# CITY OF ALBUQUERQUE

June 27, 2016

**Re: Glendesto Subdivision  
Erosion and Sediment Control Plan  
Engineer's Stamp Date 6-14-16 (B18E020)**

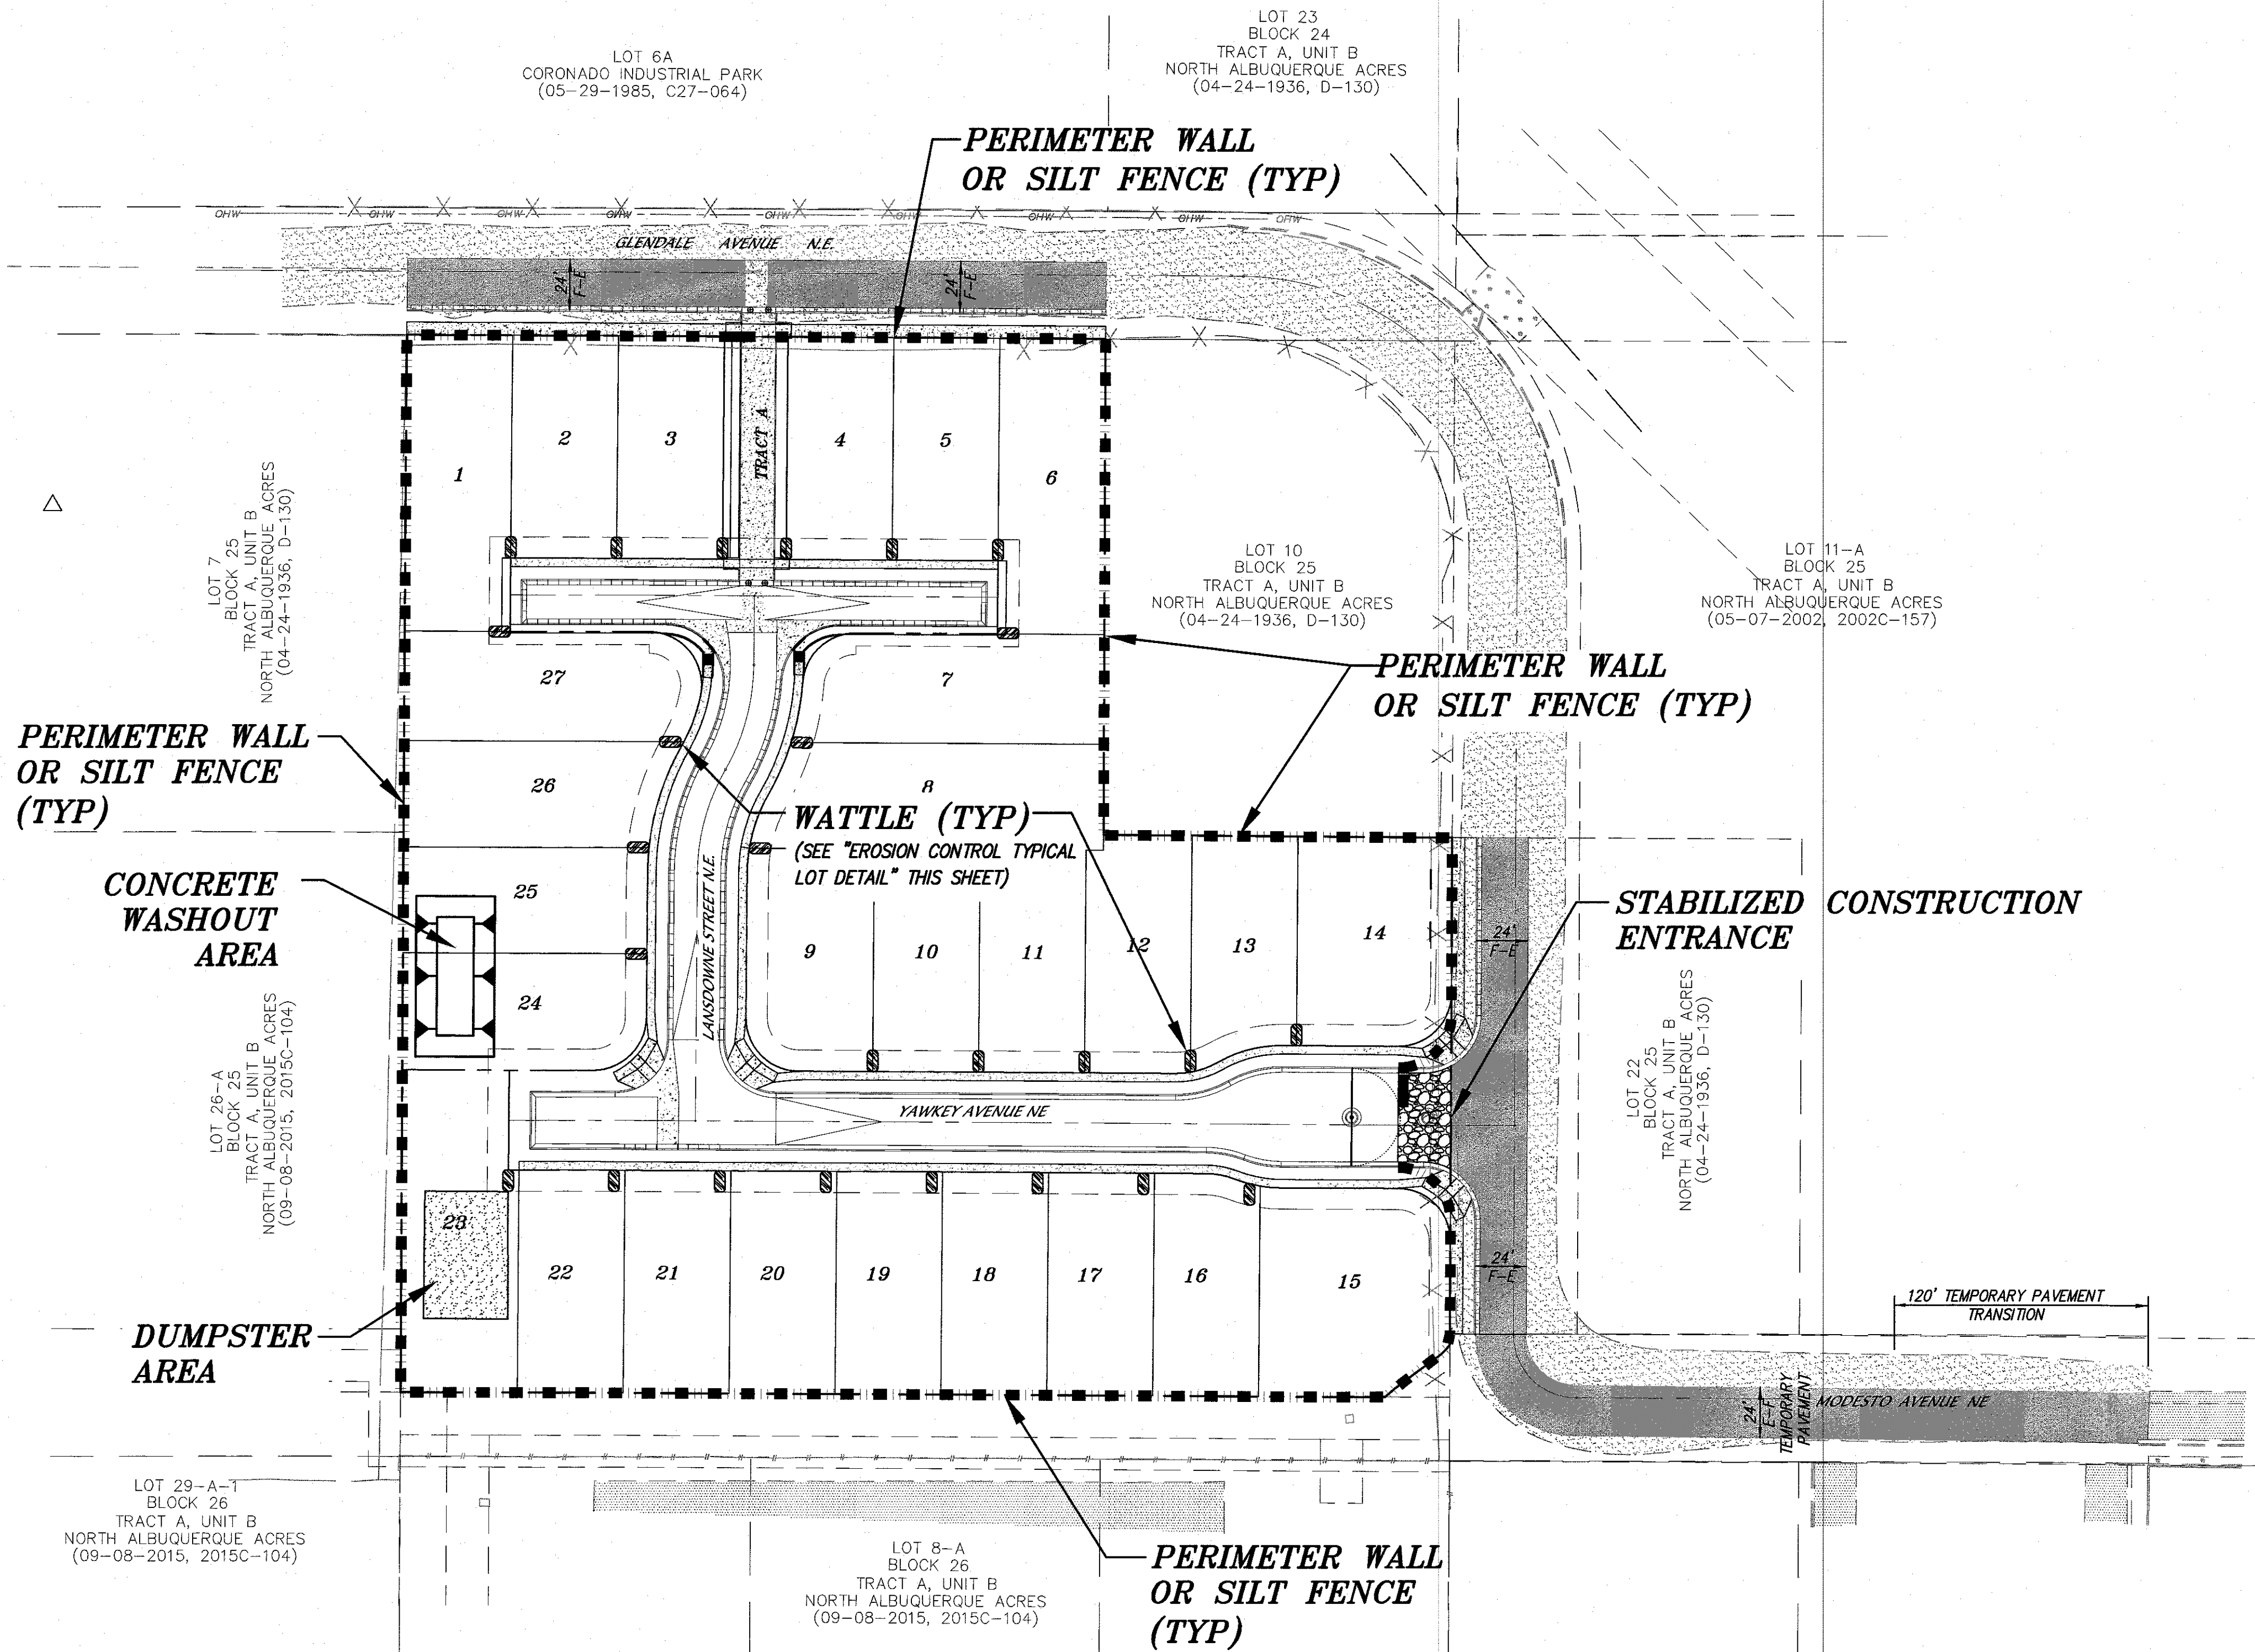
1. Sections of Modesto Ave and/or Glendale Ave. will have to be graded and paved. Provide BMPs for this work.
2. Most projects require utility cuts for water and sewer. Appropriate BMPs are required.
3. Include longitudinal street slopes on the plan.
